BROADWATER LAKE, MOORHALL ROAD, HAREFIELD

Reference: 2382/APP/2023/2906

Redevelopment of the site to create the Hillingdon Watersports Facility and Activity Centre including demolition of existing Broadwater Lake Sailing Club (BSC) clubhouse at the north of the lake and erection of a building to be occupied by HOAC and BSC including changing facilities, etc;... ecological enhancement throughout the site; new pedestrian routes through the peninsula; landscaping including new woodland, dense vegetation screens and boundary treatment; new access and access road; localised dredging and land reclamation; relocation of existing sailing area and creation of floating and fixed islands within the lake. Erection of a residential-led, mixed-use development comprising buildings... to provide 359 residential units (Use Class C3); employment floor space (Use Classes B1(a-c)); flexible commercial floor space (Use Classes A1/A3); associated car and cycle parking, highway improvements, hard and soft landscaping, plant, and other associated ancillary development.

London Wildlife Trust ('the Trust') wishes to comment on the above planning application, primarily in respect of its adverse impacts up

Figure 5.4: Extent of Dredging Zones, Island Loss & Creation and Land Reclamation

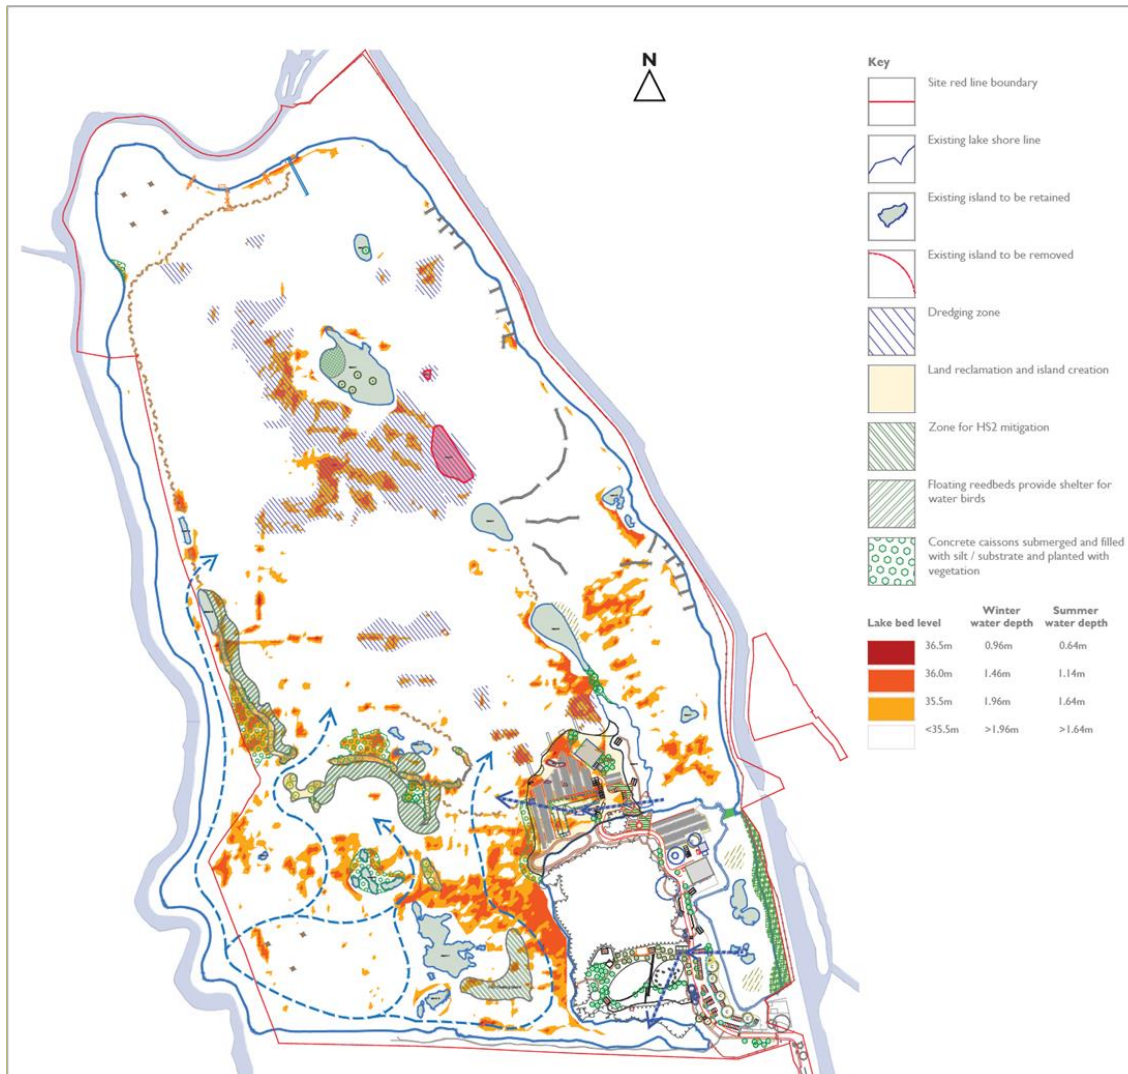
Even the construction phase impacts are alarming enough. The proposed development require land reclamation and dredging resulting in the direct loss of a variety of habitats. To enable the construction works to take place, it is proposed that over 1.6 hectares of open water will be lost as a result of land reclamation (7.6.14 in ES Chapter 7). This equates to 4.9% of open water habitat on-site and 3.1% of total water habitat lost specifically from the SSSI. This is a permanent and irreversible loss of SSSI designated land and cannot be mitigated against.

The removal of islands 2a and 3 will result in the loss of at least 10 confirmed breeding sites for various bird species. Land reclamation at the peninsula incorporating islands 8 and 9 will result in further loss of nest sites for breeding birds and a small part of up to 16 territories of 10 species may be lost (paragraph 7.6.24). Over-wintering birds may lose up to 10 winter terrestrial roosting sites through the loss of island 9 and this island has been identified as important to tufted duck, a specific over-wintering species for which this SSSI has been designated, and which were regularly recorded as using the islands (7.6.32; 7.6.33). We support the additional information set out by Natural England on the impacts caused by the construction and operational aspects of this proposal.
